Rivenhall IWMF DCO

Review of Noise Modelling Files

DCO Case Reference	EN010138
Site	Land at Rivenhall Airfield, Coggeshall Road (A120), Braintree CO5 9DF
Proposal	Rivenhall Integrated Waste Management Facility and Energy Centre.
Case Officer	Claire Tomalin
Date of request from ECC	07/06/2024
Date of response	18/06/2024
Jacobs Ref	B3553P13/93
Jacobs Consultee	Adam Baker
Information reviewed	CadnaA noise models: Rivenhall Daytime Oct23_Bssea.cna Rivenhall Evening Oct23_Bssea.cna Rivenhall Night-time Oct23_Bssea.cna

Figure 8.1: Sensitive Receptor Locations identified in Condition 38

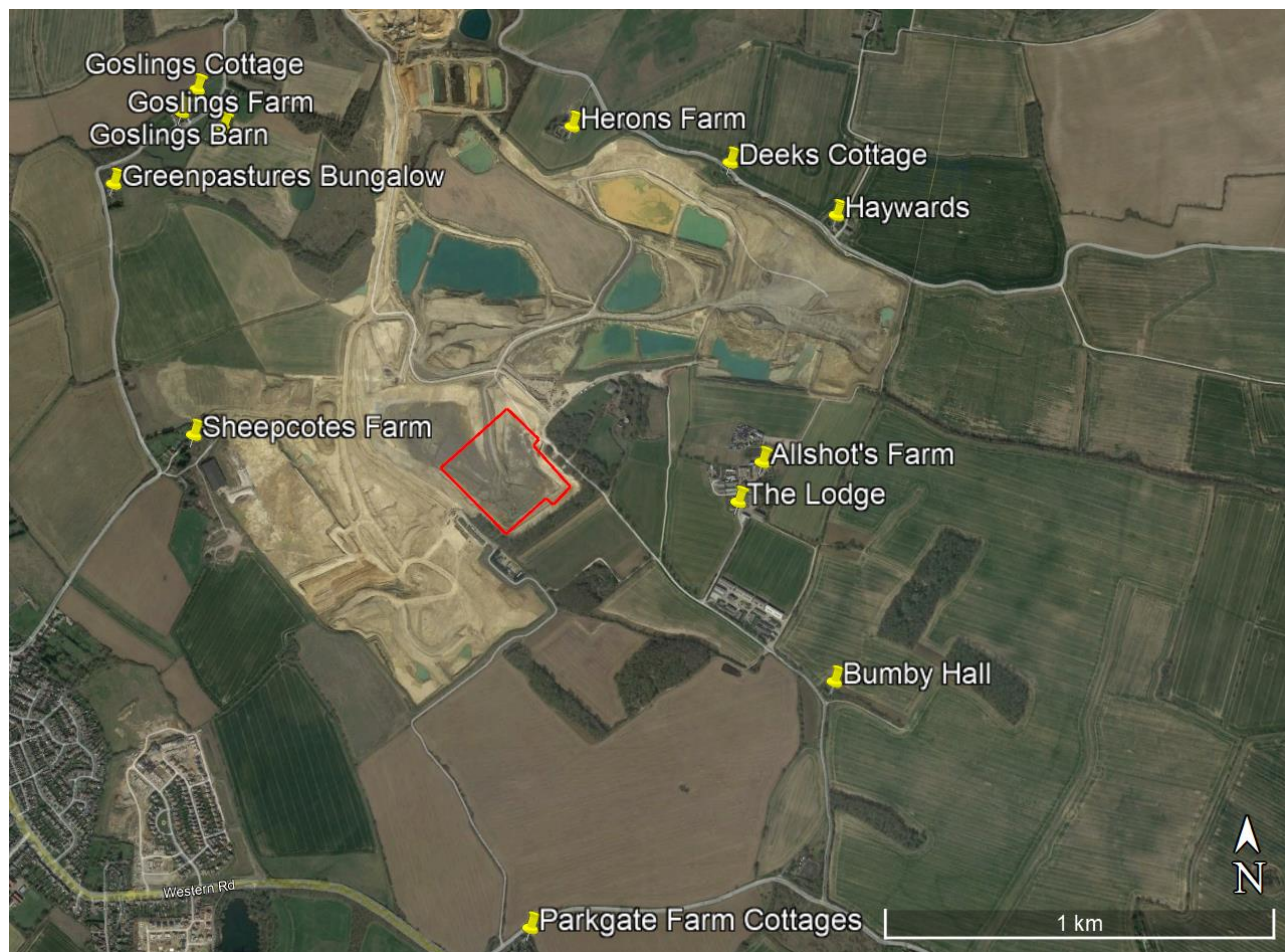
Comments
Noise receivers and existing buildings etc.	
Position	<p>All noise receivers and existing buildings seem to have been positioned using imported Google map aerial images (not embedded within model). This approach will mean the buildings (and receiver points) will not be accurately positioned (they won't match OS Master Map); however, given the propagation distance between the site and receiver points this discrepancy is unlikely to have a material impact on predicted noise levels. An example of this discrepancy can be seen in the position of the structures ~200m south of the site:</p> 
Structure heights	<p>All existing buildings are assigned a height of 8m, with the exception of the three noted above, positioned ~200m south of the site, which are assigned a height of 4m. NOTE – The Lodge is a bungalow and has been represented by an 8m tall building.</p>
Number of receivers in noise model	<p>13 receiver points, with one assigned to each noise sensitive receptor included in the assessment (12) and Jewitts Way (located south-west of the site) also included in the noise model but not in the ES. The predicted free field night-time noise level at Jewitts Way is ~6 dB lower than that predicted at the worst-affected noise sensitive receptor.</p>

Receiver height	<p>1.5m daytime & evening, and 4.0m night-time NOTE – The Lodge is a bungalow and the night-time receiver height is 4m above ground. If the 4m receiver height has been selected because the property was incorrectly identified as a two-storey property, rather than to represent window(s) at first-floor height on the western façade (i.e. facing the site), then this is likely to result in an over prediction of night-time noise level.</p>
Building external façade absorption	<p>All existing buildings, are assigned a Reflection Loss of 2.0dB (0.37 absorption coefficient). It is not clear what the rationale for this is, but it should be noted that this is a higher level of absorption than is recommended within ISO 9613-2 when this detail of a reflecting surfaces is unknown and could result in an under prediction of noise levels at receiver points.</p>
Site attributable noise	
Calculation software and methodology	<p>CadnaA software package using ISO 9613-2 prediction protocol NOTE – CadnaA updated on 06Jun to implement ISO 9613-2 (2024)</p>

Figure 8.3: Predicted Night-time Specific Sound Level at Grid Height of 4.0m – dB(A)

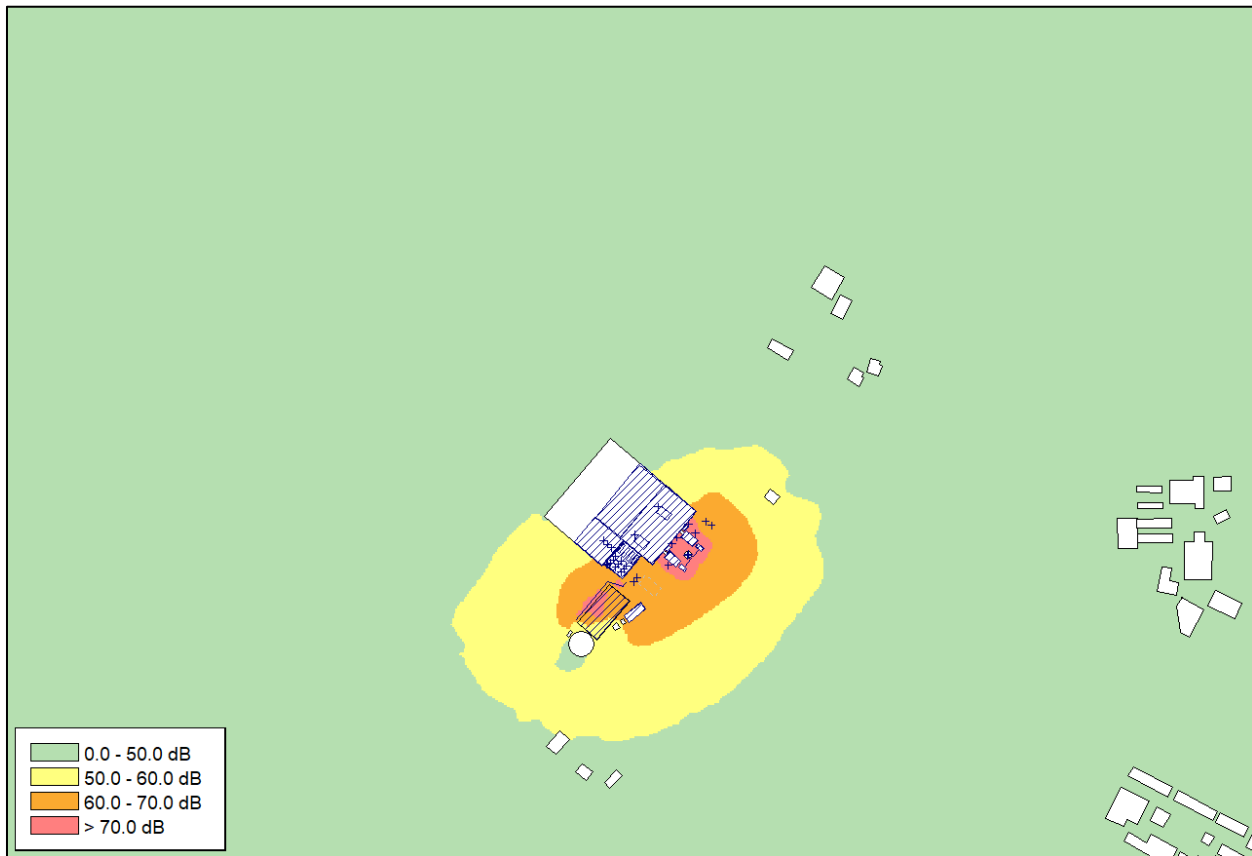
There are also potential sources of noise over prediction identified in the review, such as the receiver height at The Lodge (worst-affected receptor) at night and the omission of source directivity for noise sources where the noise propagation path is off-axis.
